Consultation Response from KC, Conservation and Design		
2020/90989 14, Edgerton Road, Edgerton, Huddersfield, HD1 5RB		
Erection of single storey extensions and rear dormer and alterations (within a Conservation Area)		
Date Responded: 08/07/20	Responding Officer: Craig McHugh	Responding Ref: Edgerton
Significance of the heritage assets affected No.14 Edgerton Road dates from c.1851 and was built as an investment for Benjamin Casson, who was high bailiff at Huddersfield County Court. Its design takes its inspiration from the 16th century, when English architecture was influenced by both French and Flemish styles and existing English traditions. The result was a composite and richly decorated style. It makes a positive contribution to the character and appearance of the Edgerton Conservation Area. The particularly fine group of Victorian and later villas set in spacious grounds on Edgerton Road illustrate the affluence and taste of Huddersfield's middle-classes in the late nineteenth and early twentieth centuries. Relevant Policies/Guidance Section 72(1) of the Planning (Listed Buildings and Conservation Areas) Act 1990 requires that the Local Planning Authority shall pay special a

This drawing is copyright.

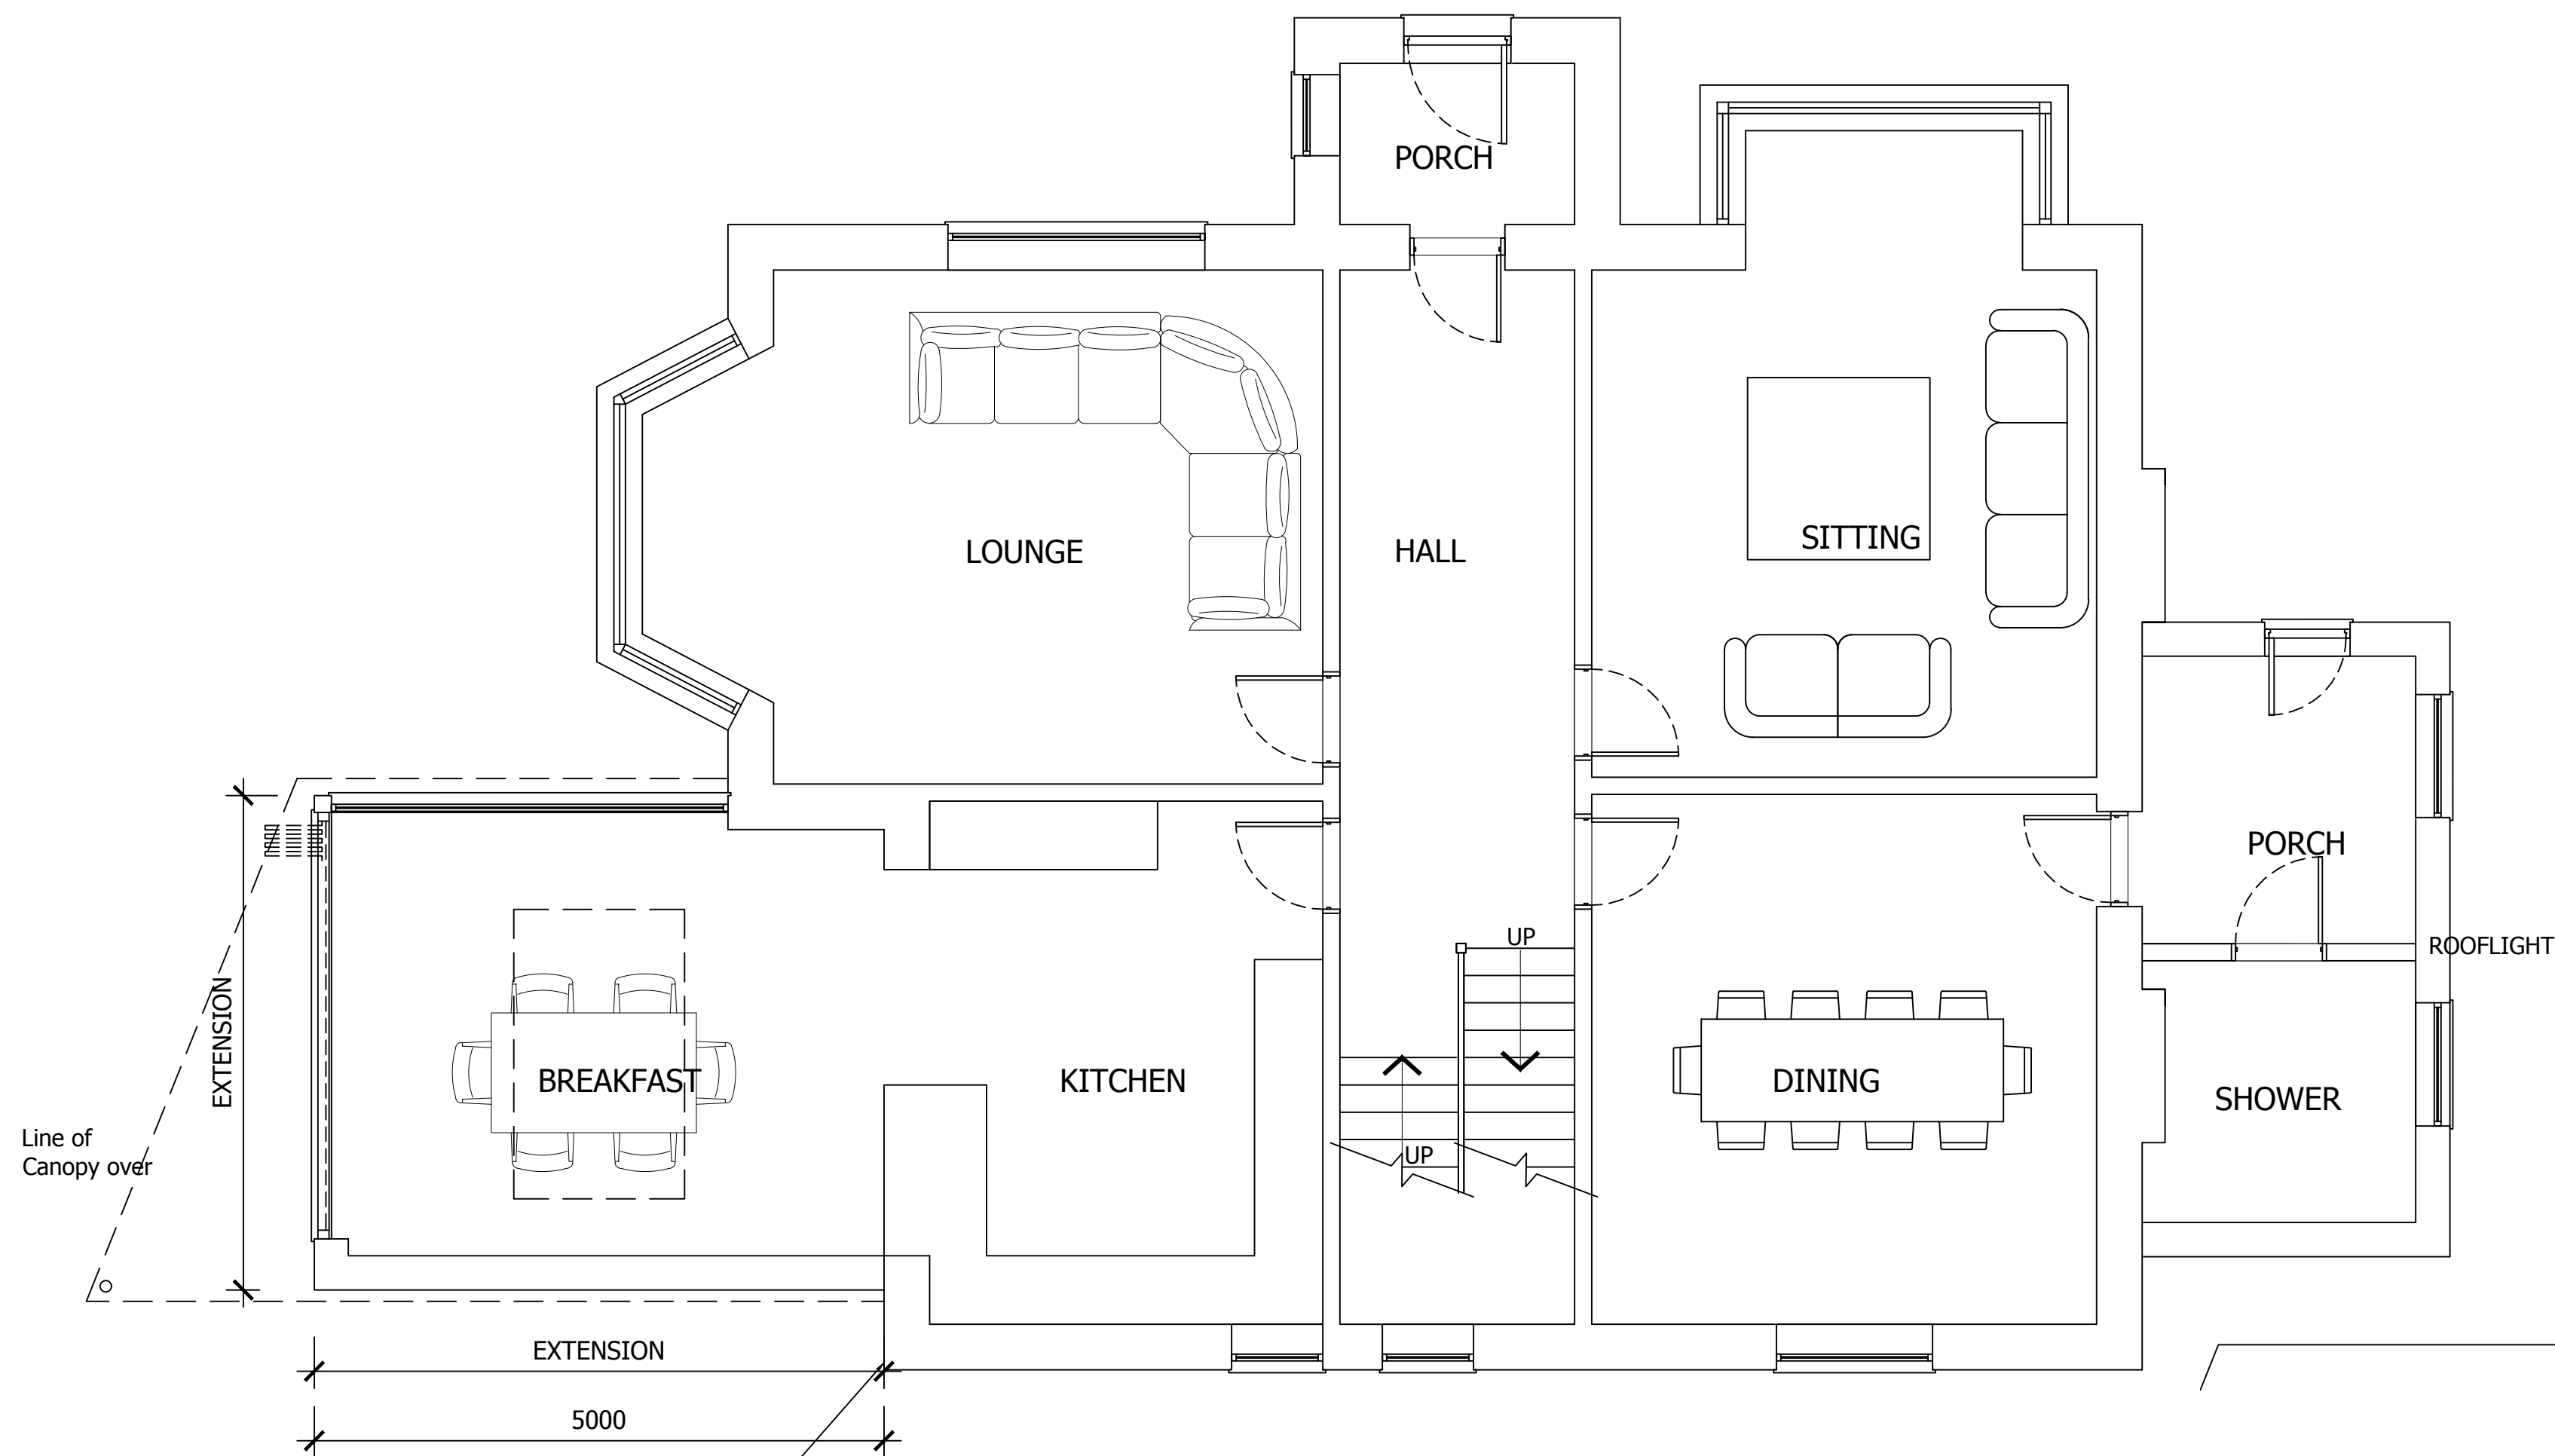
basement level and an unbroken wall above. In summary this extension does not relate to the scale, materials or details of the original building.

The existing extension to the west elevation does not respond to the character of the existing building. The proposed extension would compound that impact. The externally expressed chimney stacks should not be built across, the canopy and window proportions do not relate to the existing building. The need for a further entrance has to be questioned, could shower facilities not be located near a basement door at the rear of the building if needed?

To the rear the glass balcony at ground floor would be out of keeping with the existing building, as would the flat roofed dormer. A traditional pitched roof dormer would be acceptable. The existing and proposed drawings appear to show that the long staircase window is to be moved, this may be a drawing error as the floor plans indicate otherwise.

The need for the flat-roofed dormer spanning the double pile roof should be questioned, it is not evident how these spaces are accessed at present. Maintenance could be improved by the additional of rooflights providing for inspection and access to the valley gutter.
